**2002-0016**

Project Name/Description

**10 - 10 Dana St, Portland, Maine**

RE: Engineering Review for 10 Dana Street: Chase Leavitt Building  
ID# (2002-0016)

SITE DEVELOPMENT PLAN

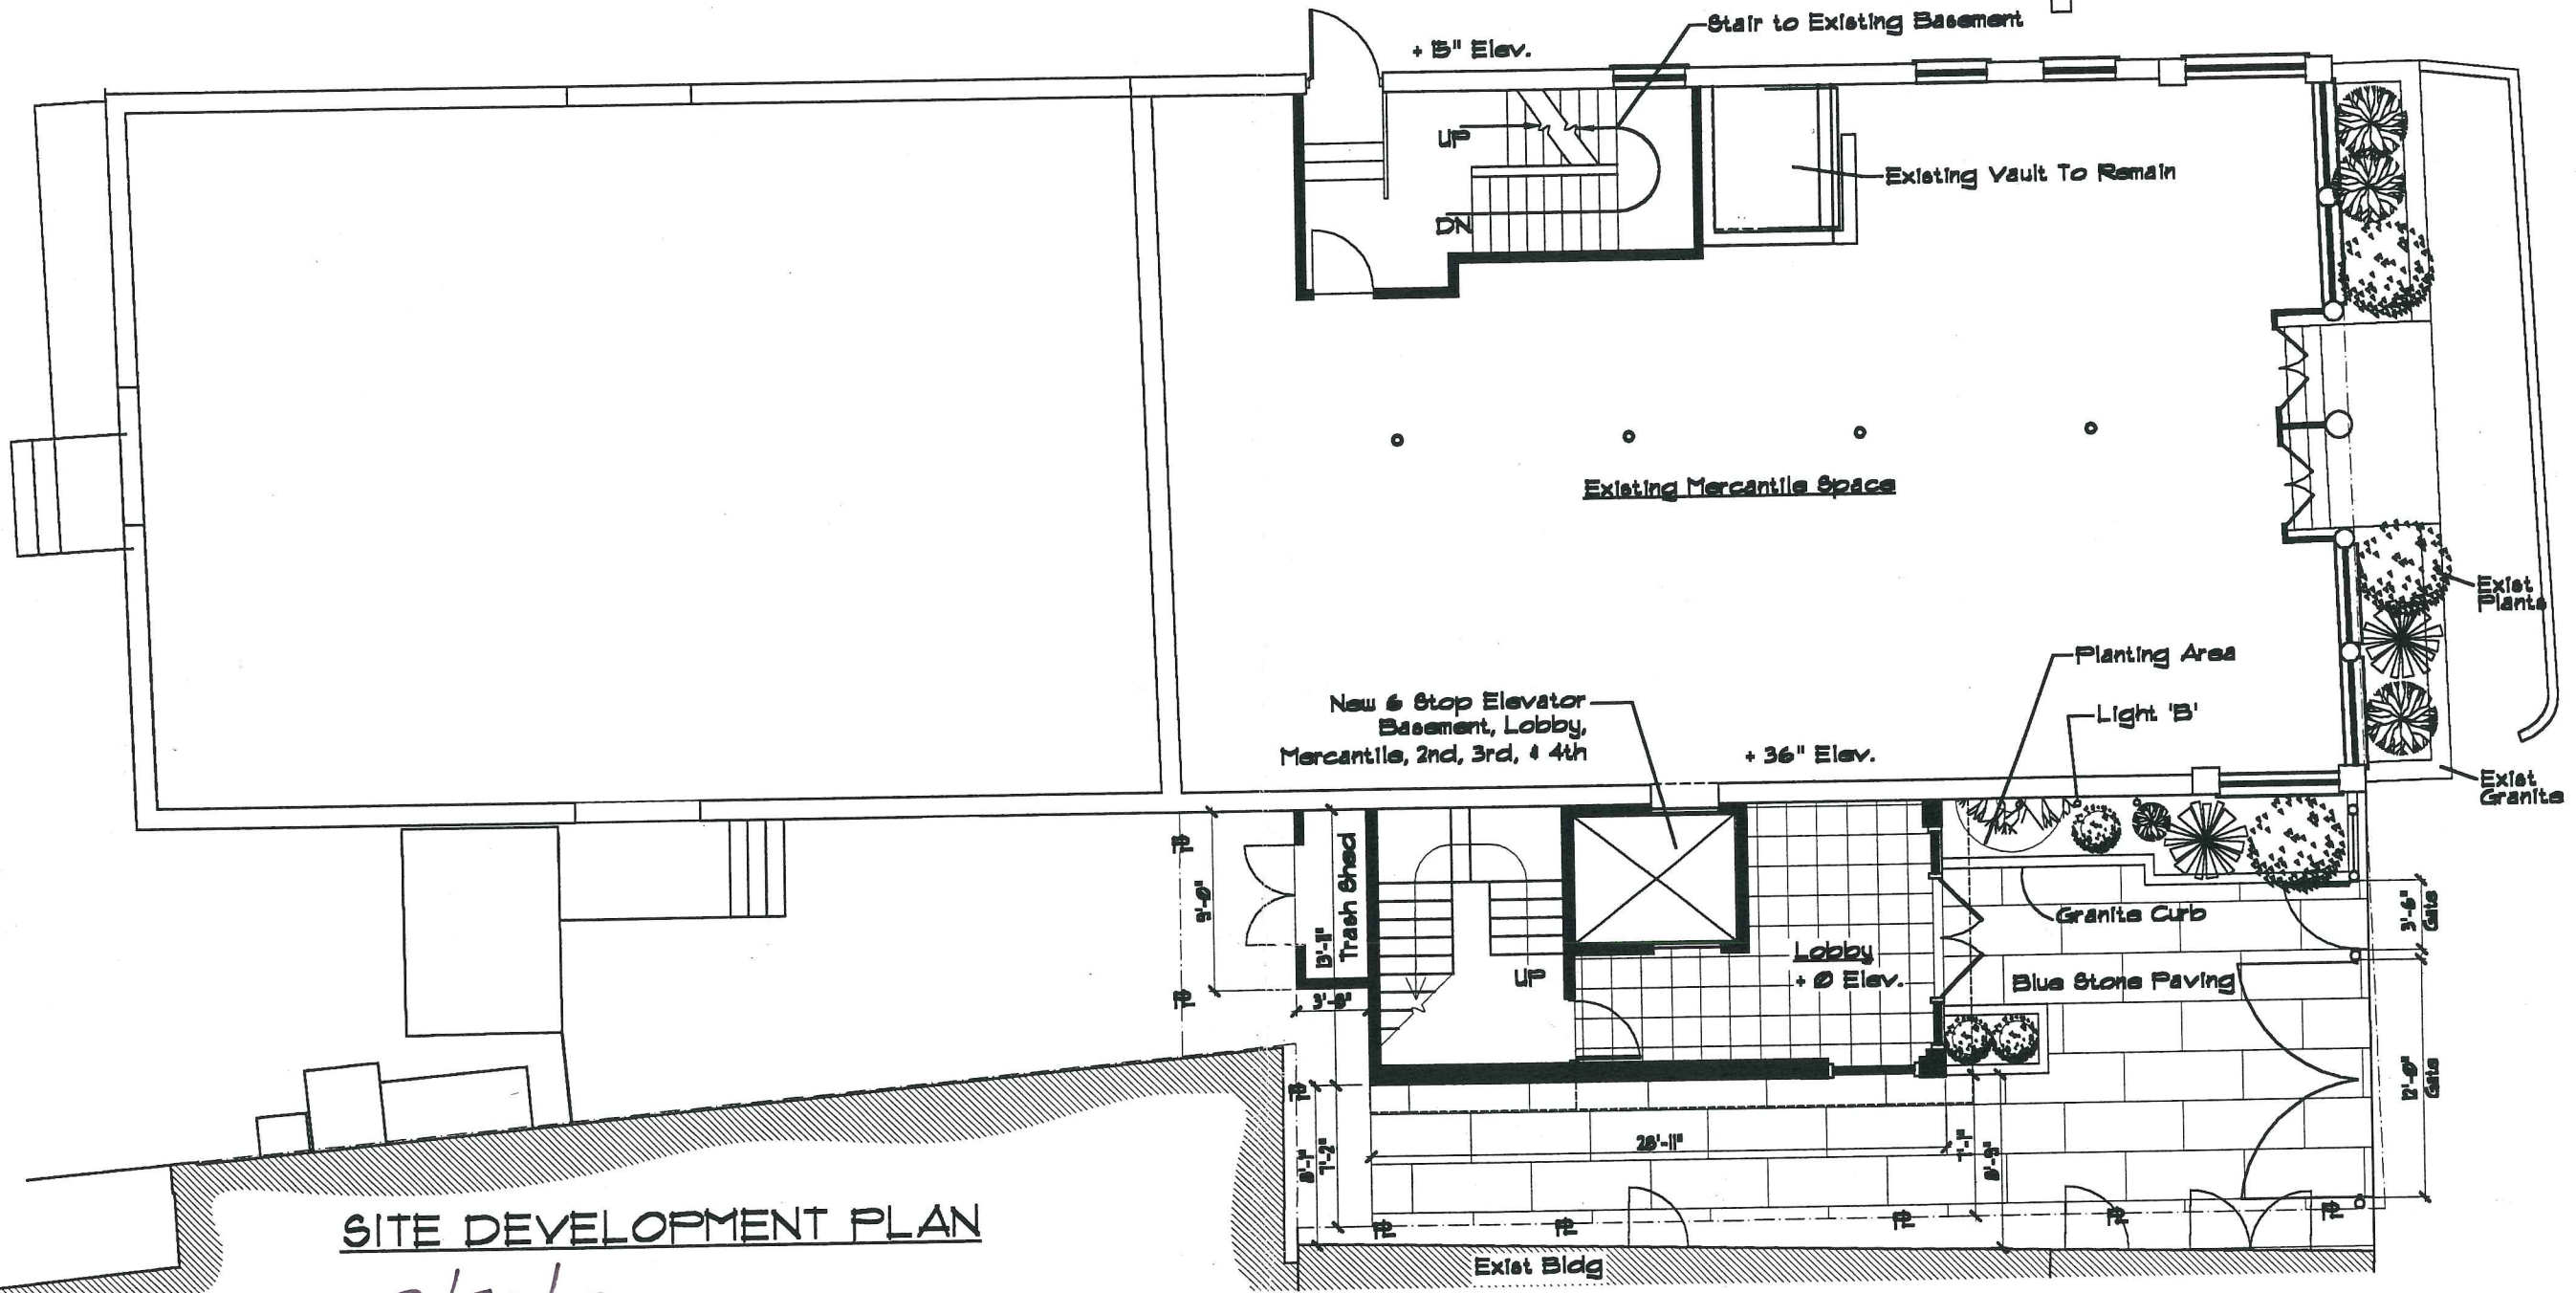
1. Drainage within the southerly premises of the building:
  - a. It appears that this area is graded correctly, and the drainage is directed properly in two directions:
    - i. Sheet flow towards Dana Street.
    - ii. Sheet flow towards Catch Basin in the Plum Street Right of way.

With no changes in topography, and assuming that the catch basin in the Plum Street right-of-way is functional and maintained, I anticipate that the proposed development will not create any detrimental drainage issues.

2. Drainage within the Plum Street right-of-way:
  - a. The area where the Catch basin is located is inaccessible. Therefore, it could not be determined at this time whether the catch basin is functional or maintained.
  - b. It appears that the installation of the patio area may be increasing drainage and/or roof drain runoff to the neighboring building's foundation.
    - i. A one foot wide crushed stone trench has been installed up to the foundation of the neighboring property, and this is acting as a place for water to percolate into.
    - ii. A brick edging between the slate patio and the crushed stone is preventing drainage from making its way to the catch basin.
    - iii. The Roof gutters from the neighboring property empty out into the crushed stone trench.
